White Rose Carbon Capture and Storage (CCS) Project
PINS Ref: EN10048

Examining Authority’s Second Written questions

Figure 1 – Noise Modelling layout, Sensitive Receptors and Emission Sources

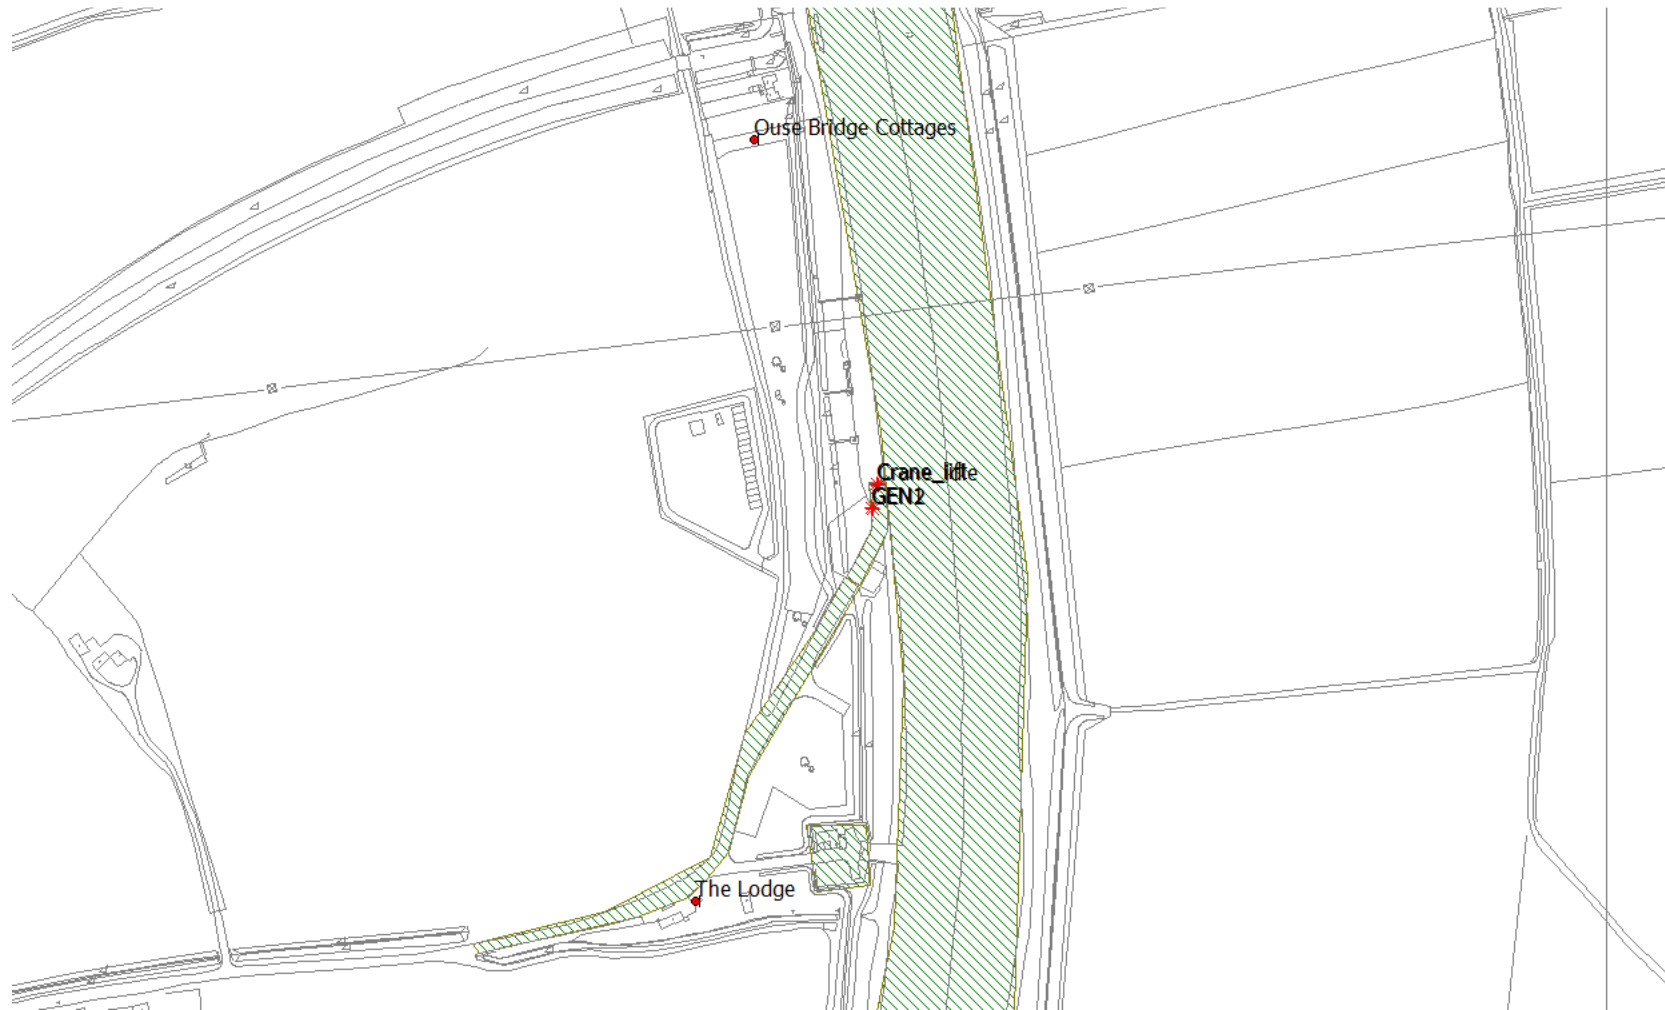
<p>To date the applicant has not provided any additional information to detail any reduction in noise due to the development of the FEED and would ask if they are able to determine how extensive an impact this may have on noise attenuation. Without this level of detail the impact cannot be quantified without assuming that there will be no improvement on the levels predicted.</p> <p>The ES chapter section 5 goes onto describe the main sound emitting equipment and any mitigation to be incorporated. The noise levels associated with most equipment is not specified and neither is the reduction due to mitigation but it does indicate where mitigation has been considered.</p> <p>In order to determine if further mitigation would be effective in reducing the overall noise levels it is necessary to first identify the dominant noise source or sources which will affect any individual receptor. Where this noise source is enclosed it may be possible to increase the mitigation by providing acoustic cladding or increasing the specification of the cladding to the inside of the enclosures.</p>

4.5	Applicant	<p>The SDC document suggests that actual noise levels, rather than 30dB, should be used in the noise assessment in para 1.2.4.</p> <p>i) Comment on the effects that this would have and whether the applicant has adopted a worst-case evaluation of the impact on receptors like Old Lodge and any other receptors that would move into the worst case category.</p> <p>SDC Answer: The properties where the night time background noise level has been amended to 30 dBA are Foreman’s Cottage, Barlow, Long Drax and Old Lodge. Only one property, Old Lodge, will move categories from the +5 to the +10. The noise level on Landing Lane and the properties affected are not presented in the ES Volume 2 Chapter B. The paragraph below Table 3.1 in this chapter indicates with respect to the measurements on Landing Lane taken in 2014 that “the measurements were limited to</p>

<p>checks in the evening and night to confirm that noise levels were below the lower threshold, and are not therefore, presented in the full table of results.” It is, therefore, assumed that the night time levels are below 30dB_A but to what extent and which category of effect they would fall is not known.</p> <p>ii. Set out the number of affected receptors in the +10dB and +5dB categories and any mitigation proposed.</p> <p>SDC Answer: Properties in +10dB category: Foreman’s Cottage and Drax Abbey Farm for both day and night time periods, the village of Barlow and Old Lodge during the night. Possibly Landing Lane, Hemingbrough.</p> <p>Properties in the +5dB category: in addition to those above Old Lodge and Landing Lane Hemingbrough during the day and night periods, Long Drax and possibly Barlow (depending on the background day time level used in the assessment) during the night time period.</p> <p>Again it should be noted that the impact on Landing Lane is not quantified. SDC cannot determine, therefore, the true extent of the increase in noise level and hence the impact.</p> <p>SDC do not have sufficient information to determine how many residential properties in the villages of Barlow, Hemingbrough and Long Drax will be affected by the increase in levels quoted by in the Table 4.2 reproduced in the document Operational Noise – Note on Technical Issues.</p>

With respect to the achievability of the levels in the table below SDC would advise you that the applicant has stated that “no further mitigation possible at this point in time for the external areas.” (Memo dated 6 February 2015 from Roderick Ellison of ERM to SDC). As discussed above this document also points out that further attenuation may be identified during the development of the FEED but it is not known how extensive this attenuation will be and if the levels below could be achieved. At the current predicted levels at the receptors the limits given in version of Requirement 2 given below will not be achievable for the following properties:
